Our ref: DOC21/238759
Senders ref: SSD 10479

Subject: amended plans and documentation for the proposed 200 Aldington Road Industrial Estate (SSD-10479) in response to issues raised with the Applicant's Response to Submissions

Attachment A – EES comments on Response to Submissions for 200 Aldington Road Industrial Estate (SSD-10479)

EROSION AND SEDIMENT CONTROL PLAN
SHEET 1

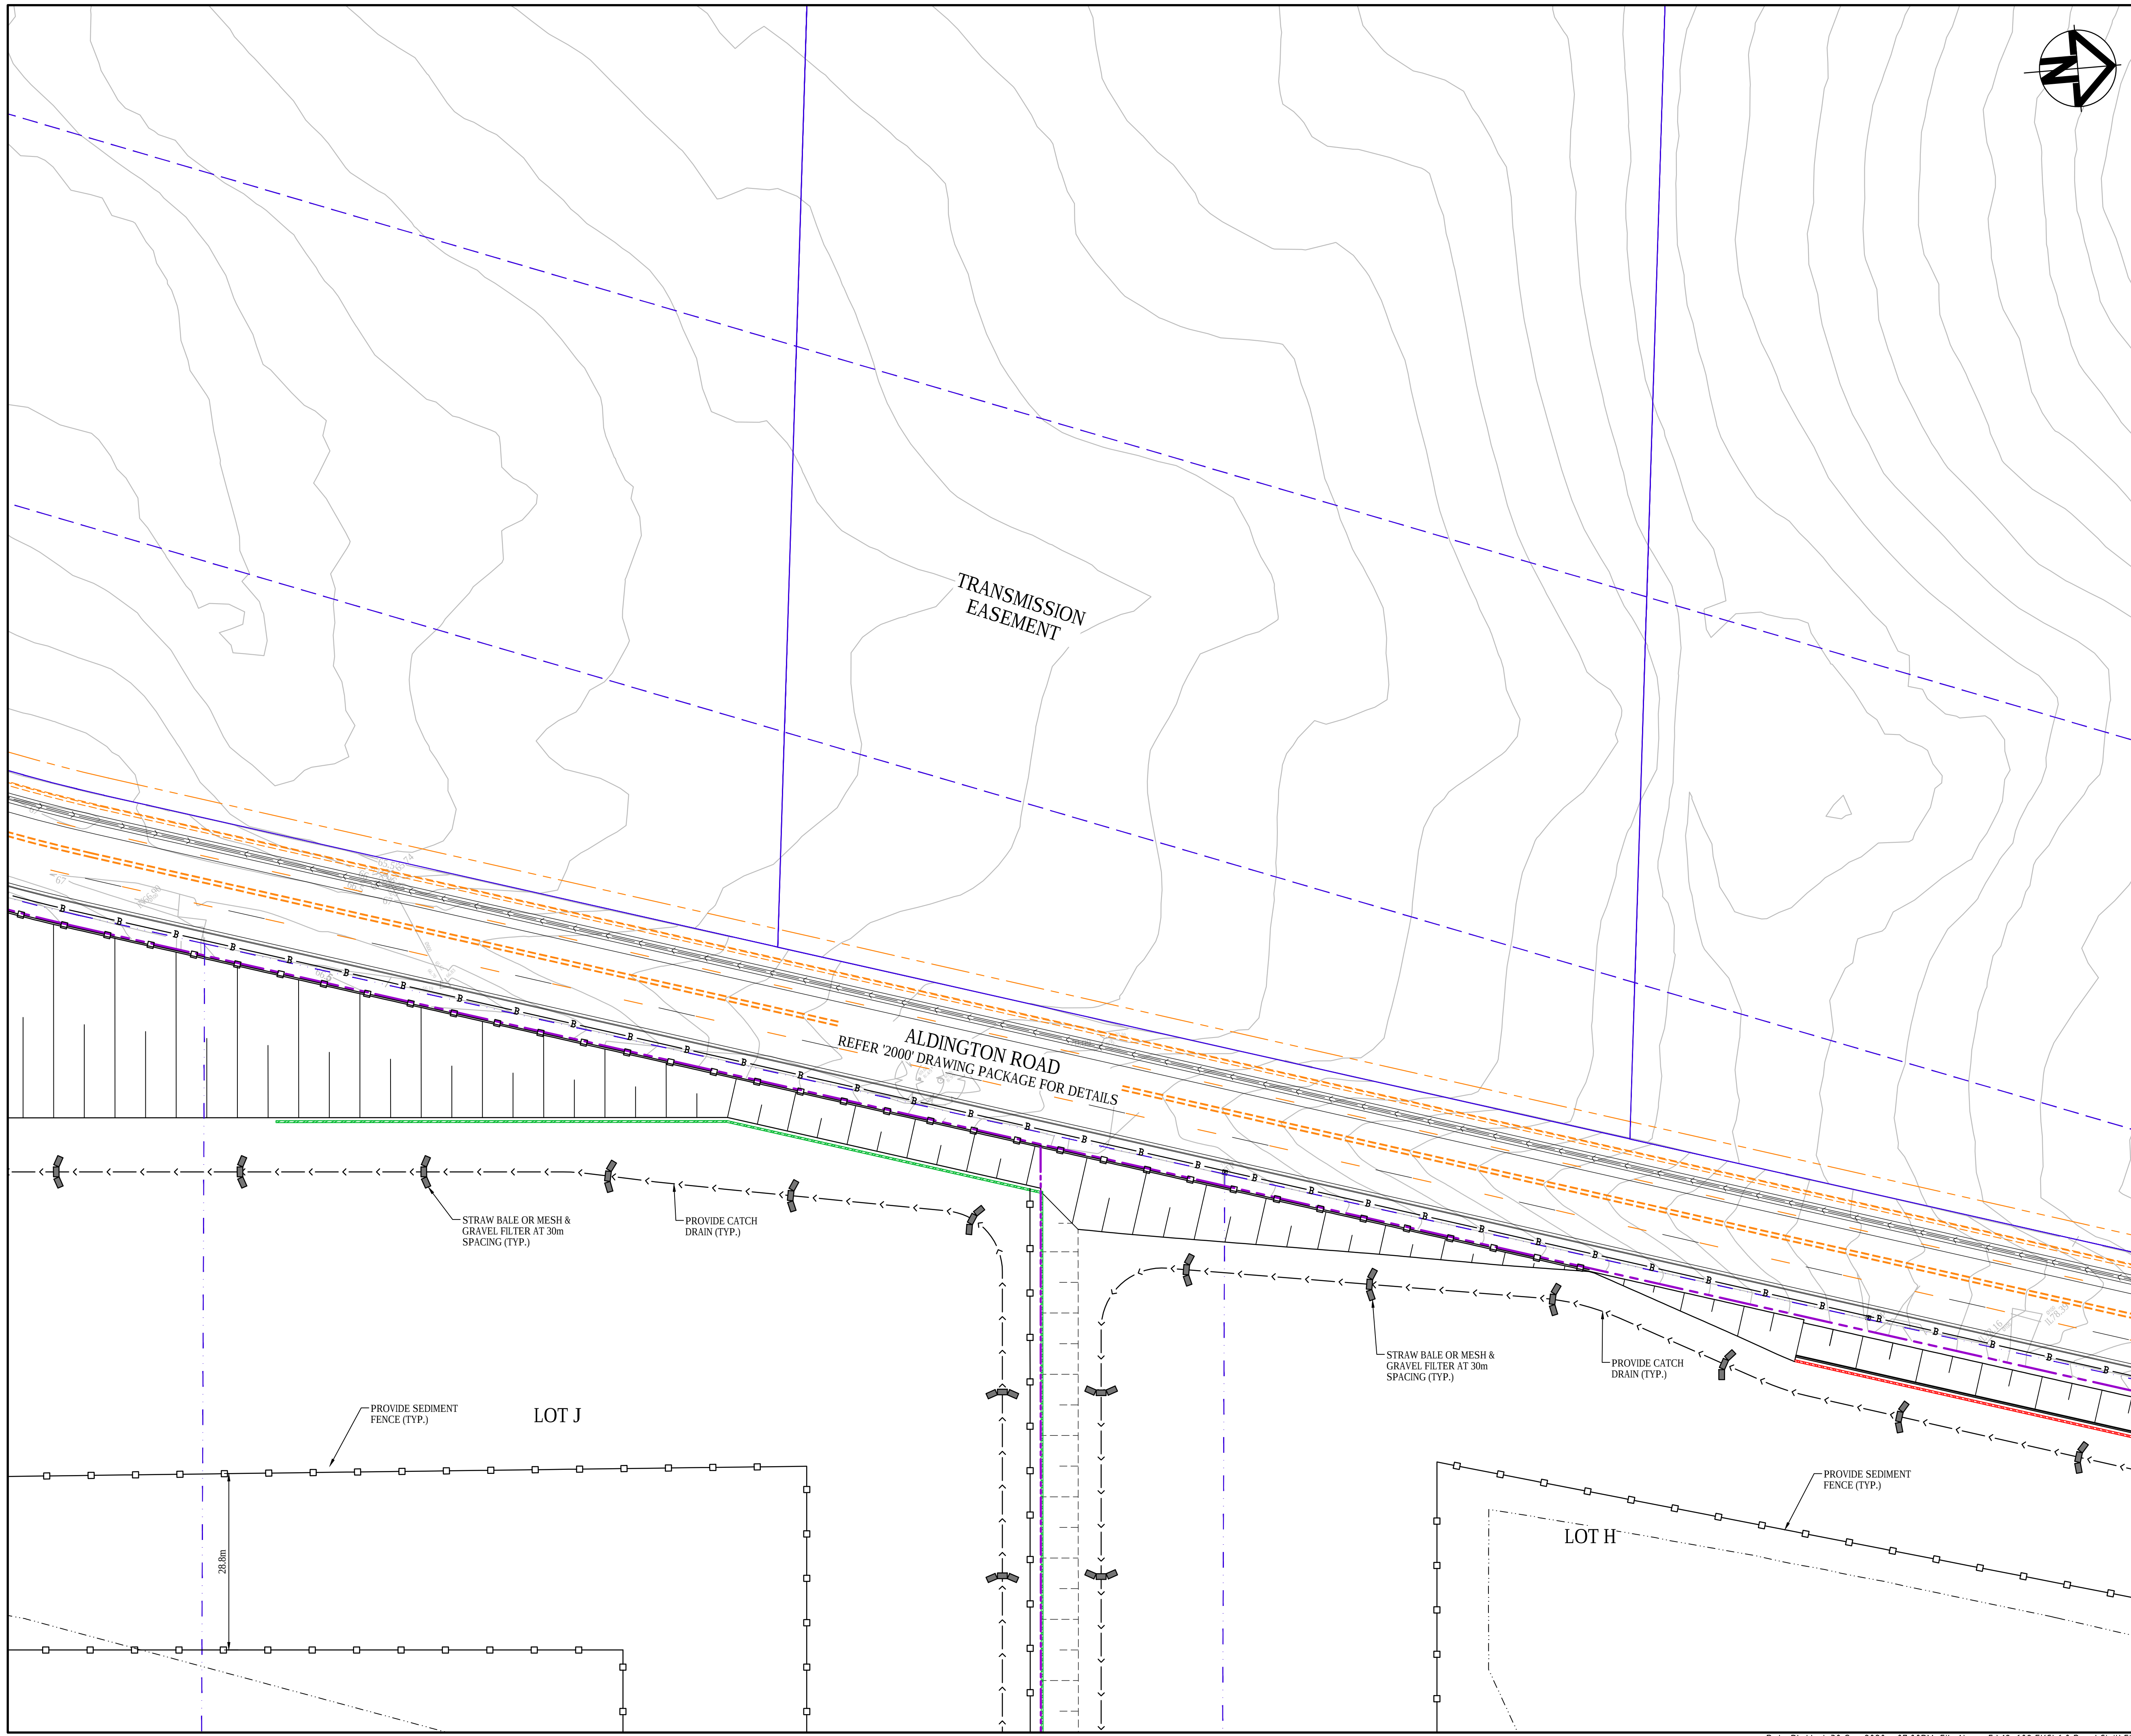
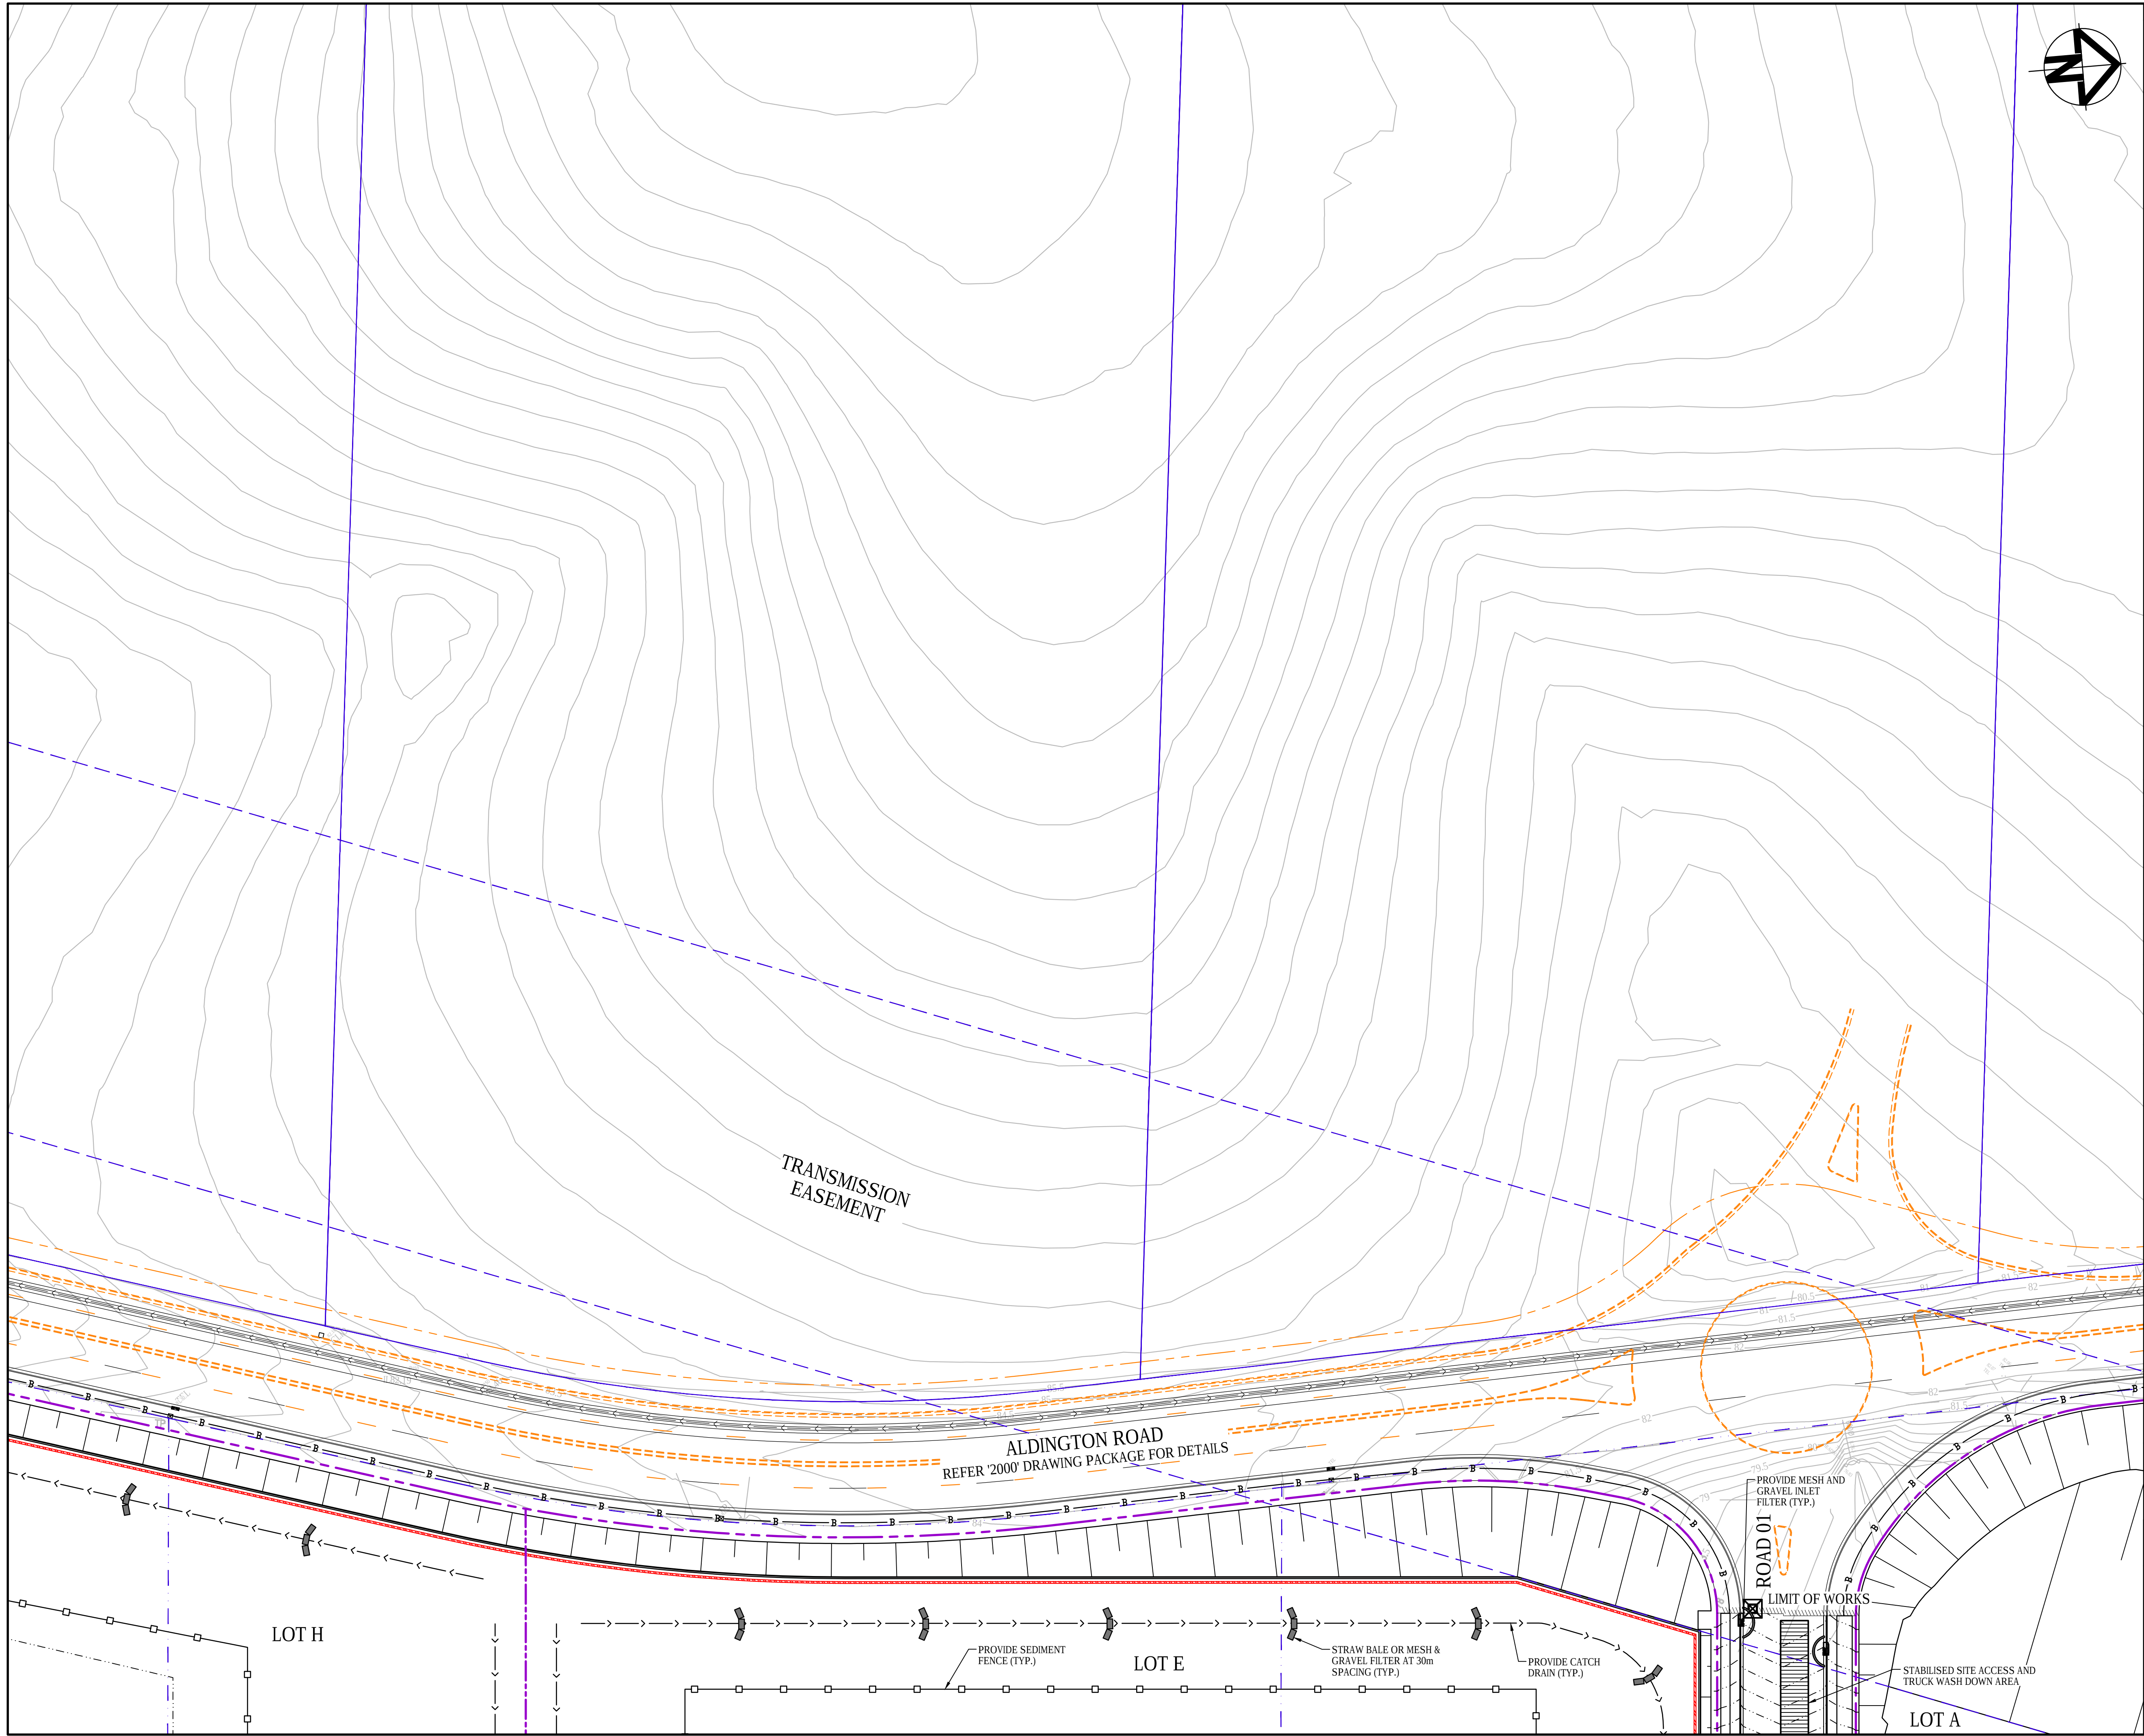
Section 8 – Sedimentation and Erosion Control

Sedimentation and erosion controls should demonstrate that EES's Construction Phase Targets are being achieved. Please refer to Table 1 of the EES 'MUSIC MODELLING TOOLKIT – WIANAMATTA' previously provided to DPIE Planning and Assessments Group on 5 August 2021.
